**KIRKLEES METROPOLITAN COUNCIL
INVESTMENT & REGENERATION SERVICE**

Reference No: 2019/62/92519/W

Site Address: 3, Cobcroft Road, Fartown, Huddersfield, HD2 2RU

Description: Erection of single storey rear extension and two storey side extension (within a Conservation Area)

Drawing	AD-A-405 -102	Revision:	
---------	---------------	-----------	--

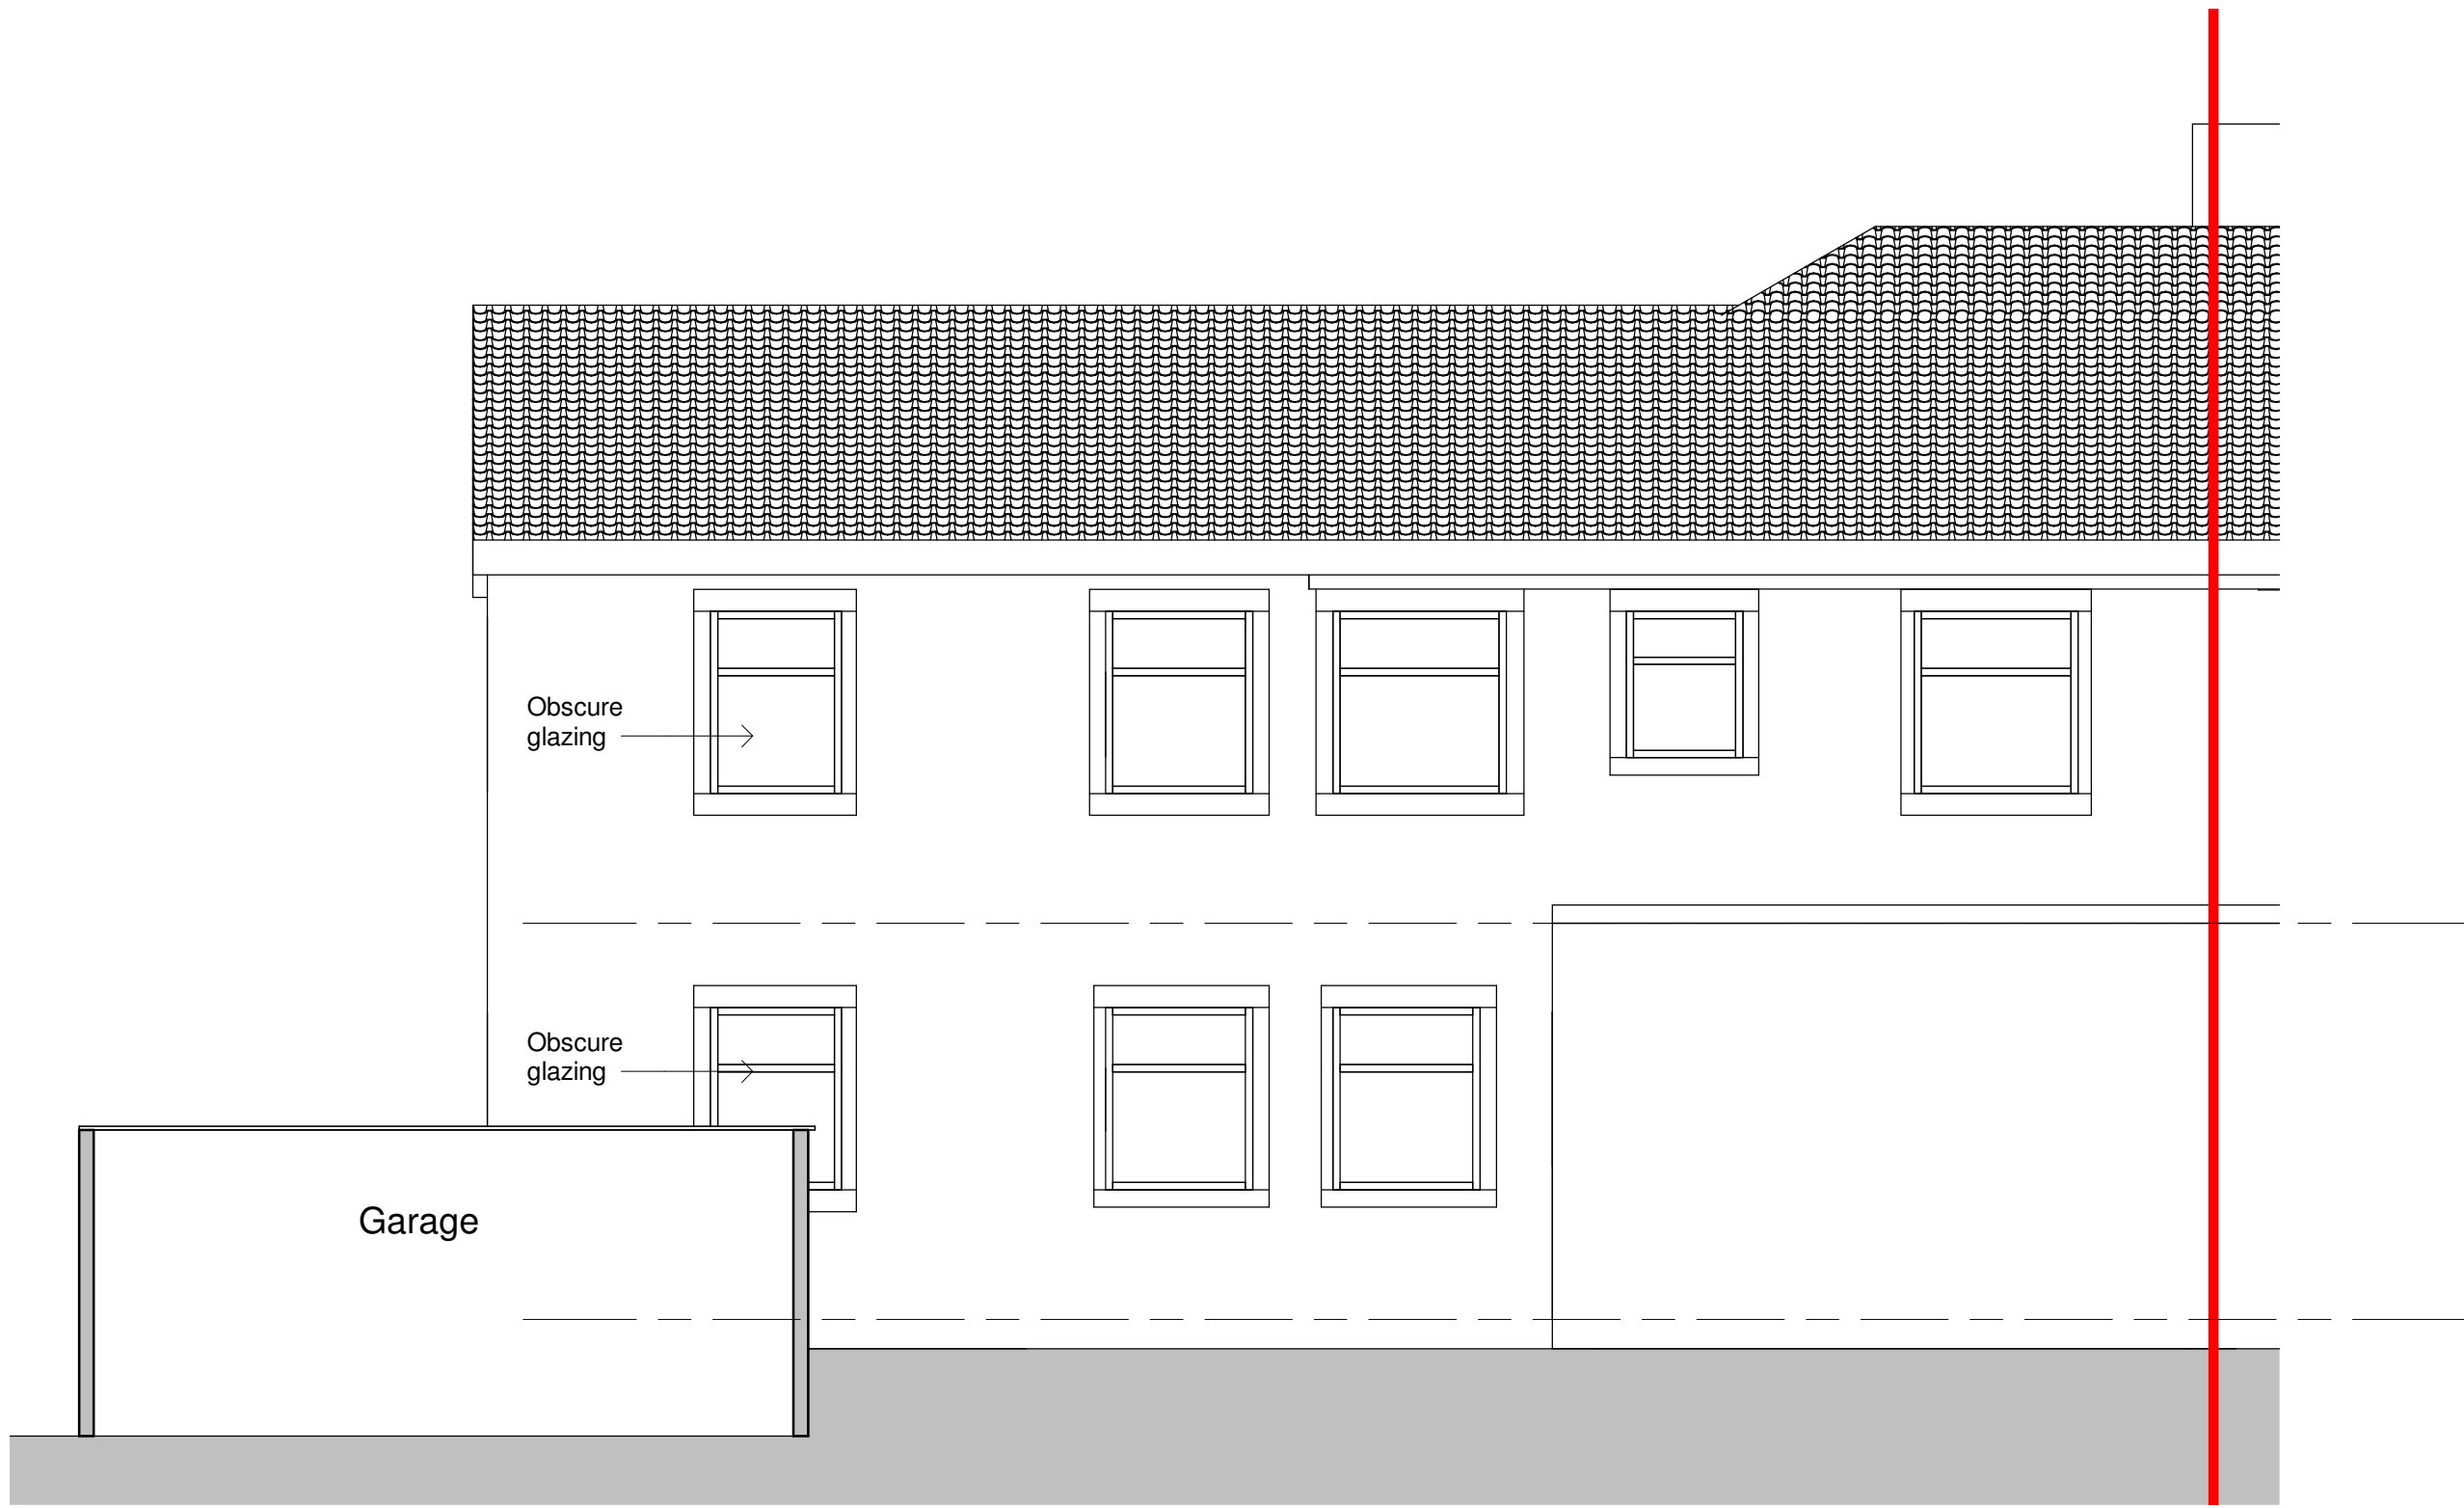
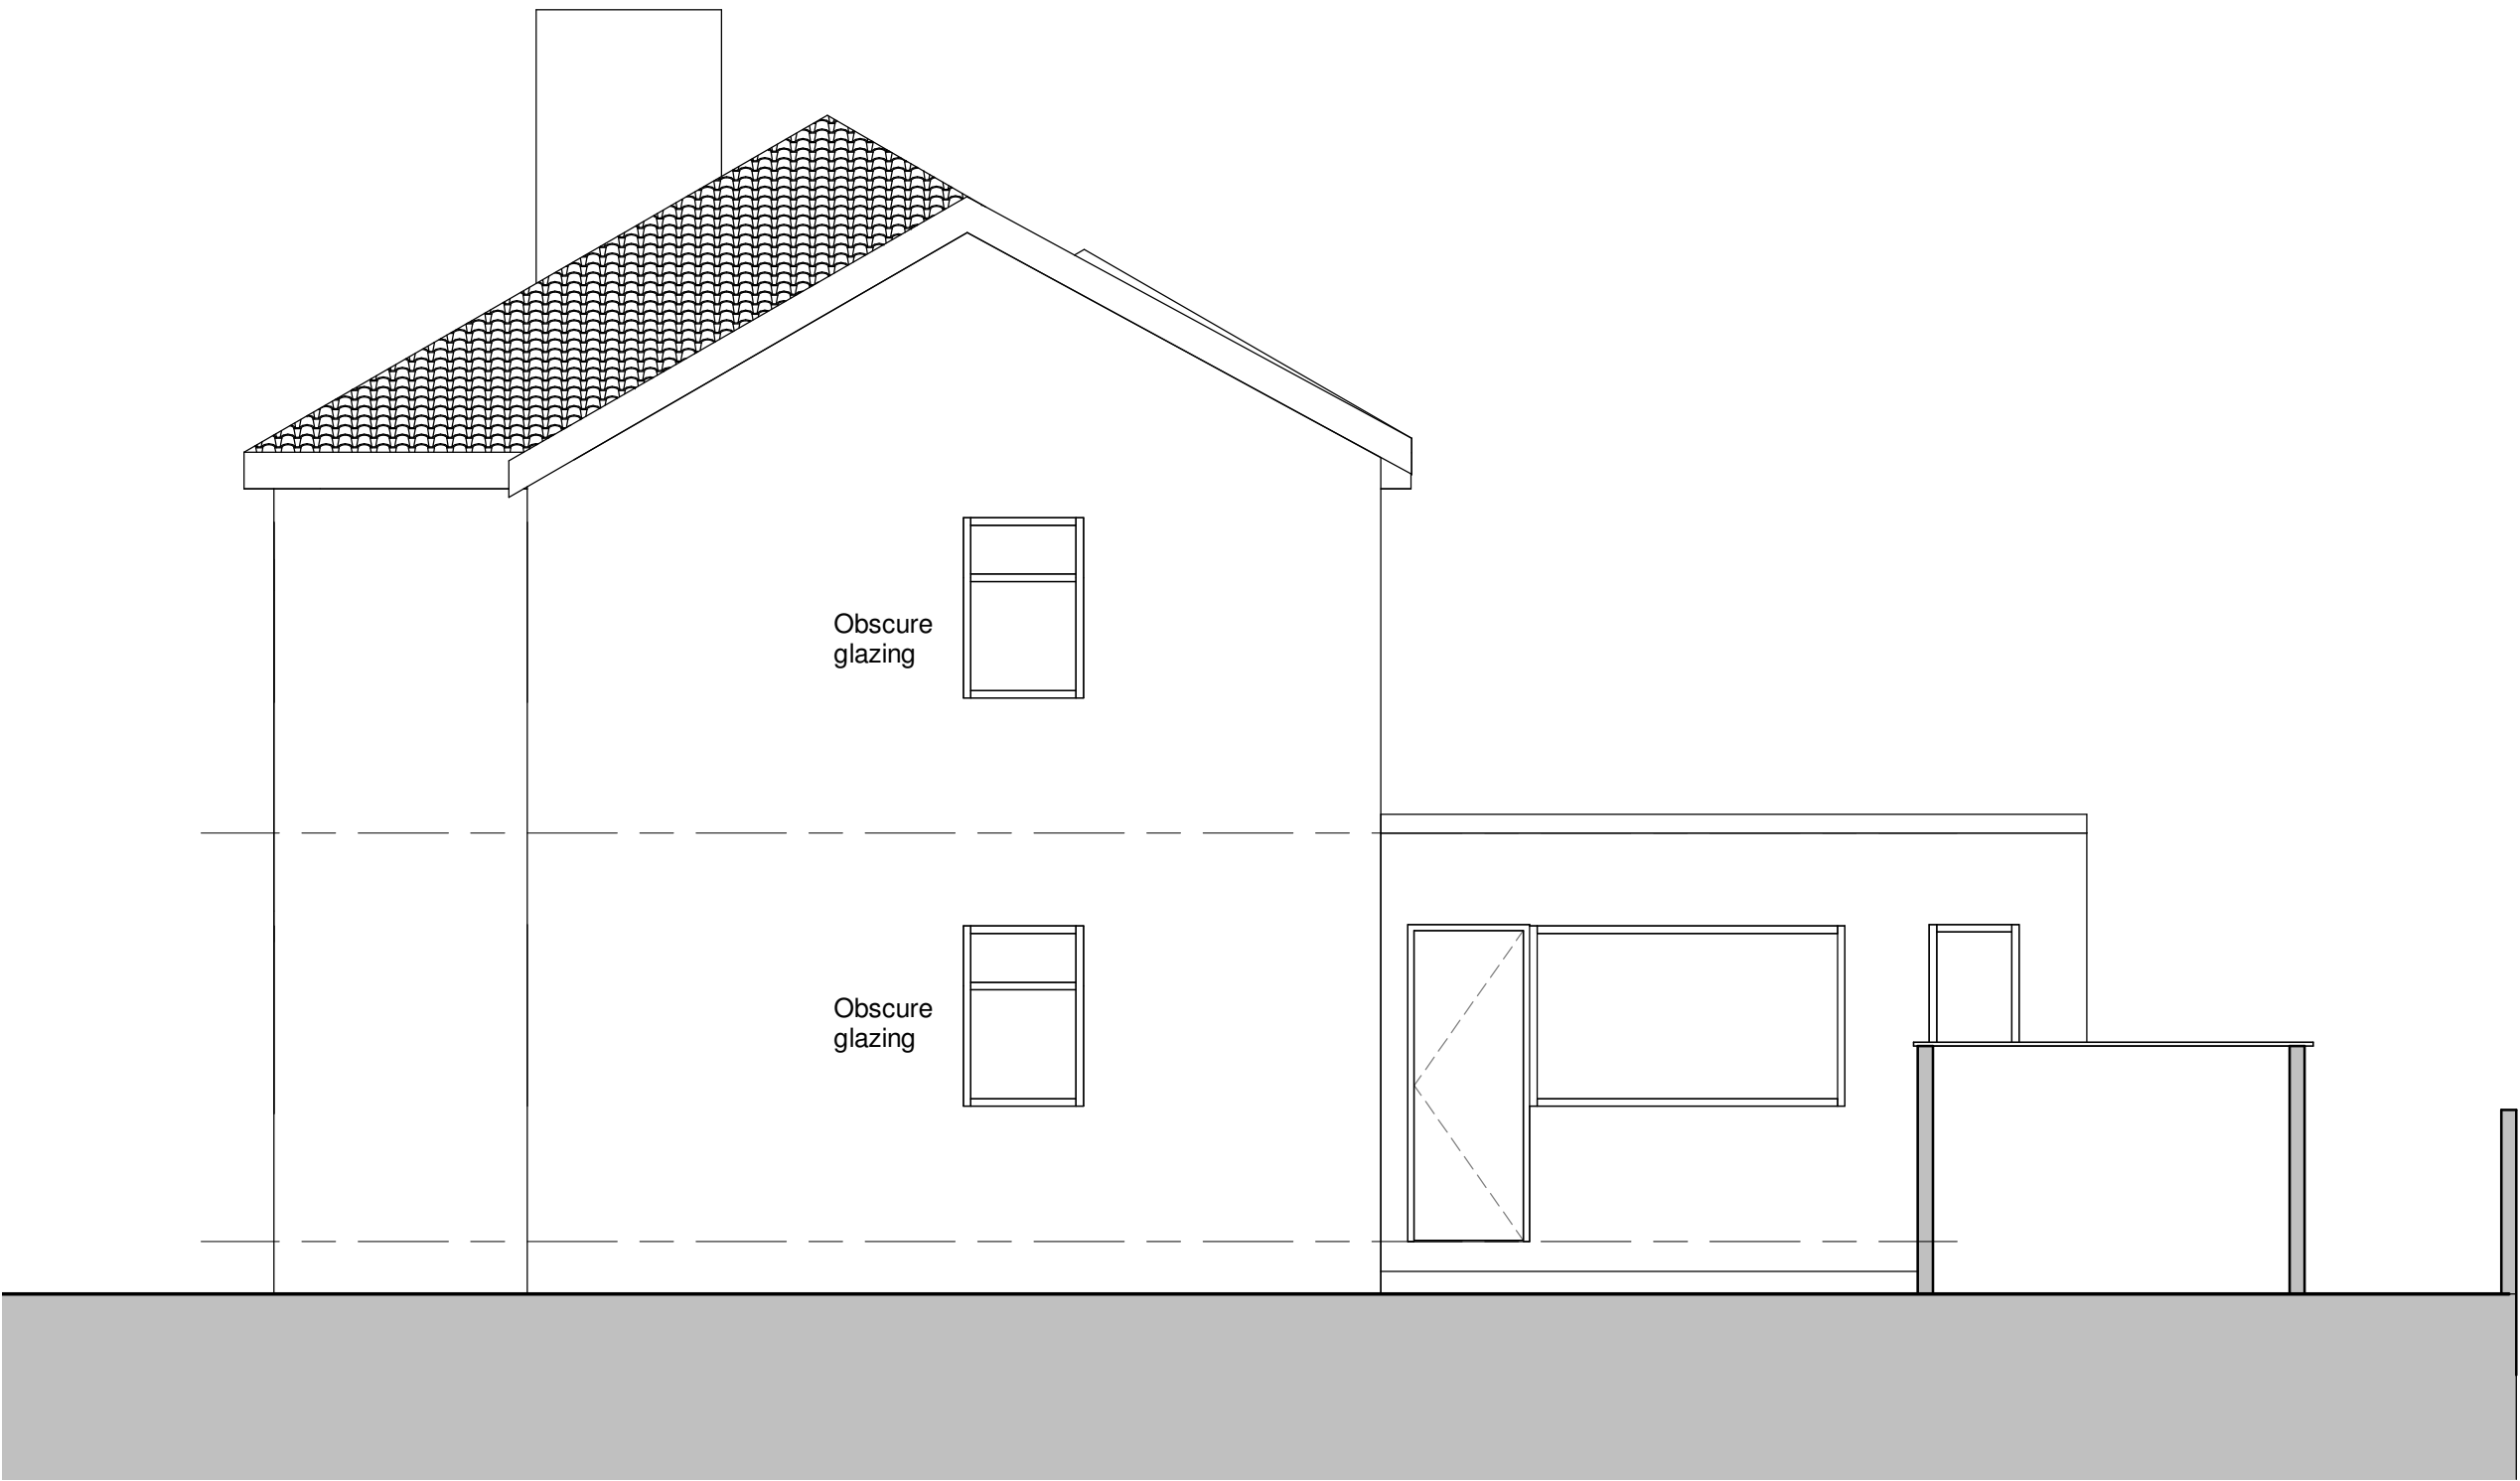
Given the position of the dwelling in relation to Cobcroft Road, it has been assessed that there would be some impact on the appearance of the street scene, as the side extension in particular, would be readily visible from public vantage points. As such KC Conservation and Design have been consulted, in which concerns were raised as the original plans were considered to have a significant impact on the character of the semi-detached properties and the wider street scene. More specifically the officer raised concerns, in regards to the fact that the extension would not follow through with the symmetrical design. Therefore, to overcome some of the harm, concerns were raised with the agent regarding the above and amended plans were received on the 30th September 2019.

After reviewing the amended plans, it has been considered that the design of the two storey side extension would have an acceptable impact on visual amenity, as it would follow on from the original property and harmonise well with this and other half of the semi-detached pair. The building materials would match those that exist on the host property and therefore would allow the extension to harmonise well with the existing. Nonetheless, a condition will be attached to the decision notice to ensure visual amenity is protected.

The additional fenestration within the front and rear elevations are also considered satisfactory as they will be in keeping with those that exist on the host property. For these reasons, it has been noted that the initial concerns raised by the Conservation and Design officer have been overcome.

In regards to overlooking, the submitted plans show two additional openings to be inserted into the rear elevation of the two storey extension. These will be obscurely glazed and therefore, any harm on overlooking would be minimal. Nonetheless, a condition will be attached to the decision notice stating that these openings will be fitted to a minimum of grade 4.

2 and 4 Cobcroft Road are the neighbouring properties adjacent to the front elevation of the host property. It has been assessed that there would be some harm on these neighbours amenity however, the submitted plans show the side extension to sit flush with the front elevation and therefore any harm on overbearing and overshadowing would be minimal.

Alongside this, it has been noted that additional openings will be inserted into the front elevation of the side extension. These appear to serve bedroom 1 and 5 and therefore there will be some impact on overlooking. However, it has been considered that any harm would not be over and above the existing situation.

The officer entered into discussions with the agent regarding the design of the two storey side extension and therefore amended plans were received on the 30th September 2019. The officer also entered into discussions with the agent regarding an updated site plan which was received on 4th October 2019.

KC Conservation and Design (informally): Concerns raised regarding the two storey extension having a symmetrical design. Amended plans submitted have overcome their concerns.
